Proposed amended modification design (subject to approval) of the Crescent overpass and green link:

Application number SSI 7485

This is a submission drawing attention to significant shortcomings in the amended modification design for the proposed Crescent overpass. I object to these deficiencies and propose an alternative which overcomes the shortcomings.

Figure 4-2 Pedestrian and cyclist bridge infrastructure options

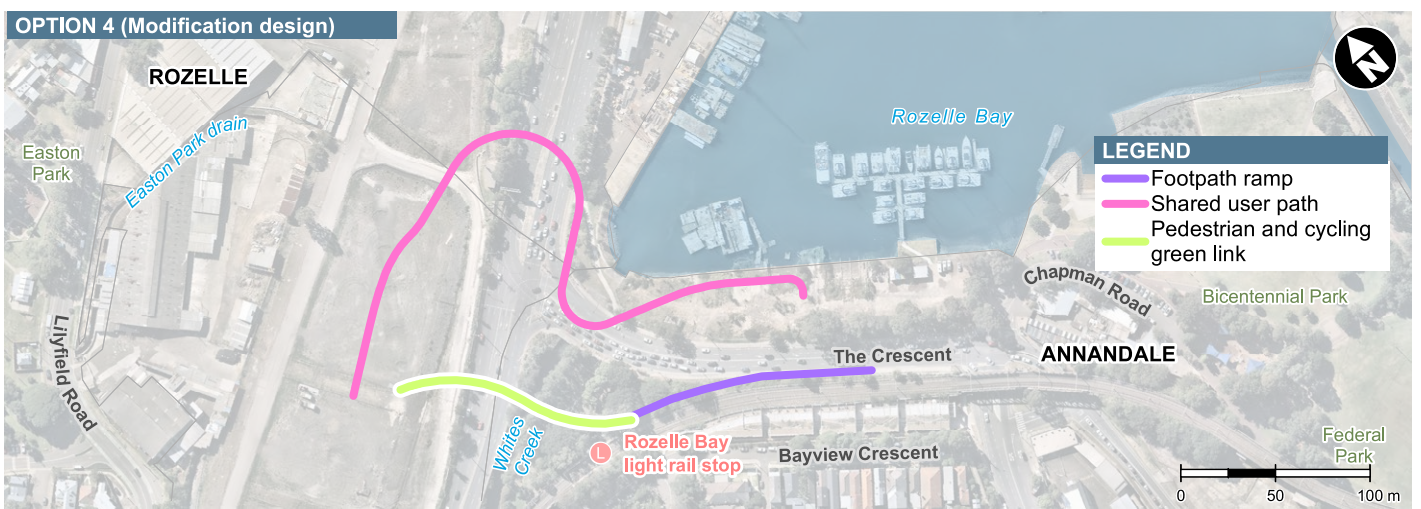
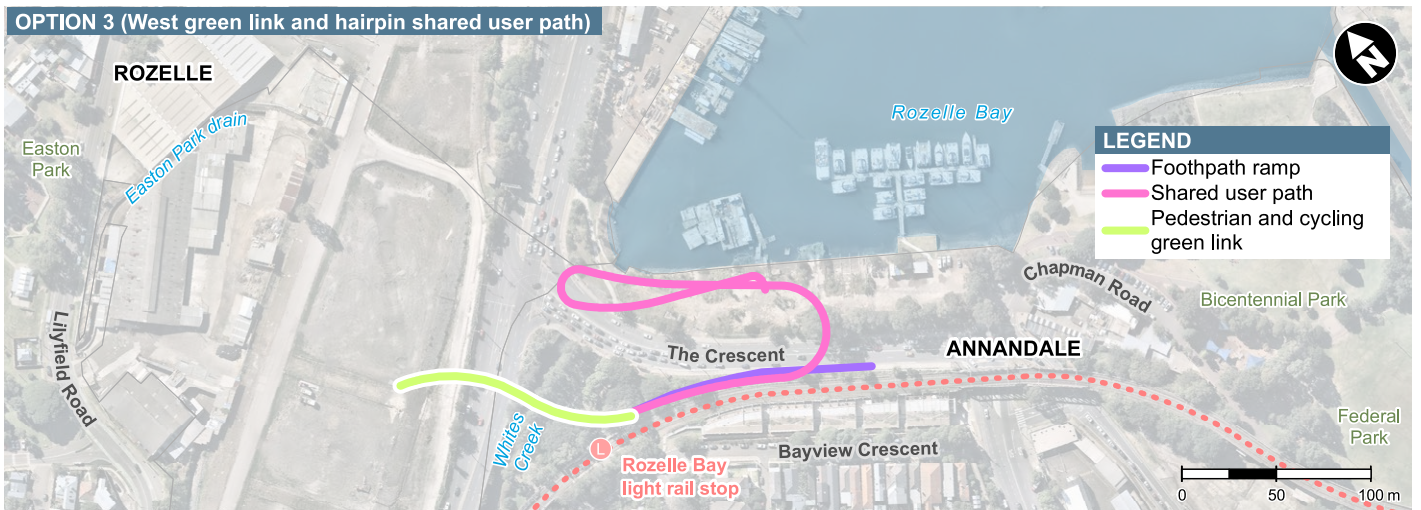
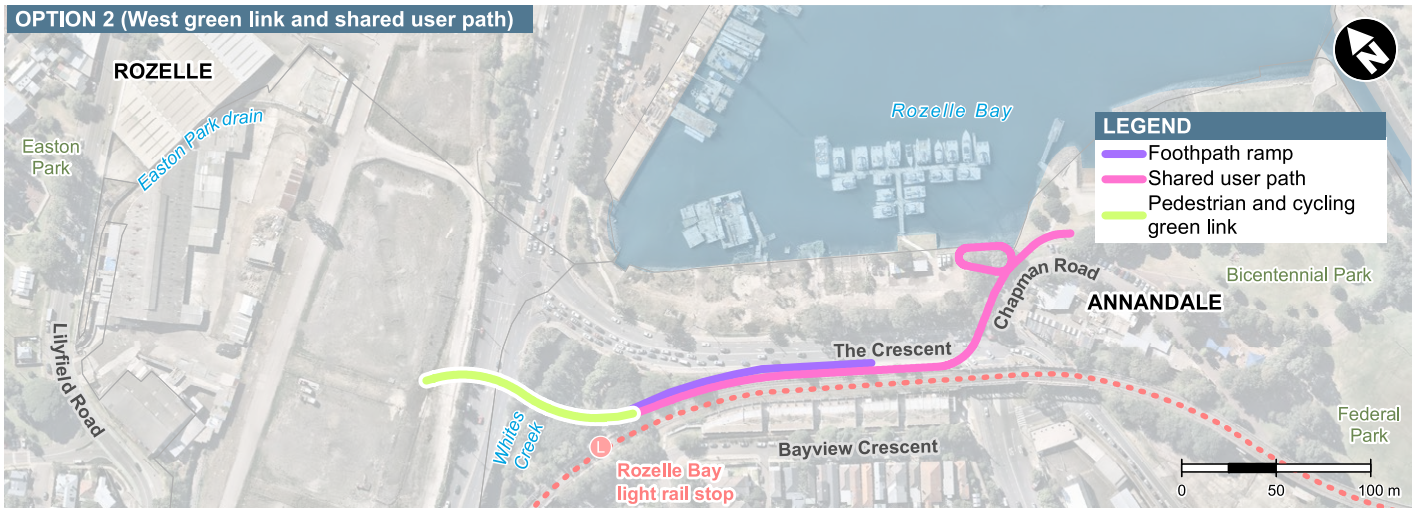
At least the horseshoe bridge DID provide a direct link (without having road crossings) between Rozelle and Annandale parklands (even if it was a bit of an eyesore and was very long). But your modification has deleted this overpass/bridge.

I trust that you will take my objections and suggestions seriously and if you are unable to deliver the direct link that was originally promised and approved then consideration should be given to re-instating the horseshoe shaped bridge which does at least provide this direct link.

**Figure 10 |** Indicative pedestrian and cyclists crossing over The Crescent and Johnston Street  
(Source: Response to submissions on Design Amendment Report)

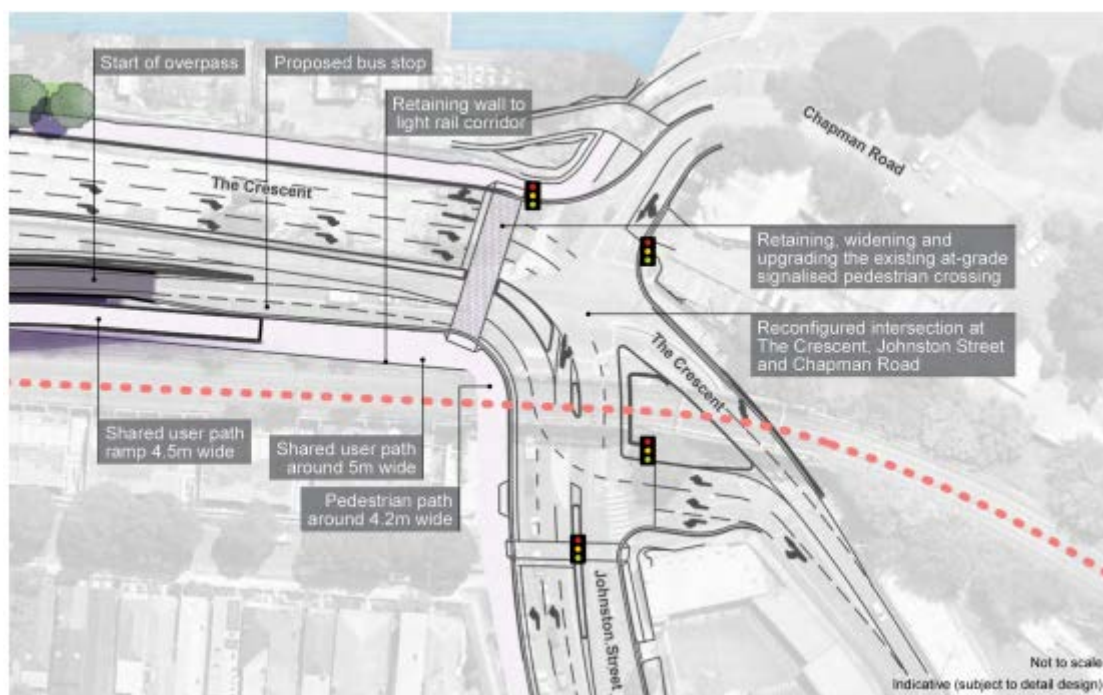
What has been proposed is shared but is not direct; it is not especially wide and is only partially green. But the glaring issue is that the free movement of pedestrians and bike riders is brought to a dangerous, abrupt, halt by a pedestrian crossing and traffic lights. This arrangement is probably slightly better than the original proposal (with the traffic overpass) but it is still unsatisfactory and smacks of a lack of imagination and good-will. I think WestConnex can do much better.

Basically, what I think could overcome this pedestrian-crossing-obstacle is a simple overpass of the crescent with a ramp to the foreshores on the Annandale side. (See diagram below).

A cross section drawing at the point of the proposed overpass is shown below from the current design amendment. Below that is a superimposed impression of the proposed overpass and ramp.

Current (revised) proposal: Pedestrian crossing for 6 lanes of traffic to access foreshore

Alternative with shared access direct to Annandale foreshore

There are many ways an overpass could be engineered for this situation and I have simply suggested a suspension type of bridge that can be constructed offsite and swung into position when ready. It has a single support in the median strip. The length of the access ramp would need to be adjusted to allow both pedestrians, bike riders and wheel chairs to access relatively easily. (The ramp could go either towards Bicentennial Park or towards Whites Creek (or both ...with dual ramps)).

The overpass and ramps could be made quite wide to accommodate appropriate “green” landscaping or sculptural treatment. The path alongside the light rail track could overhang (possibly cantilevered) the lower ramp for a considerable part of the distance and thus allow a wider path. And there is no real restriction on the width of the overpass itself apart from engineering/cost issues. I have suggested that it should be at least 6m (hopefully more) in keeping with the original approved design concept.
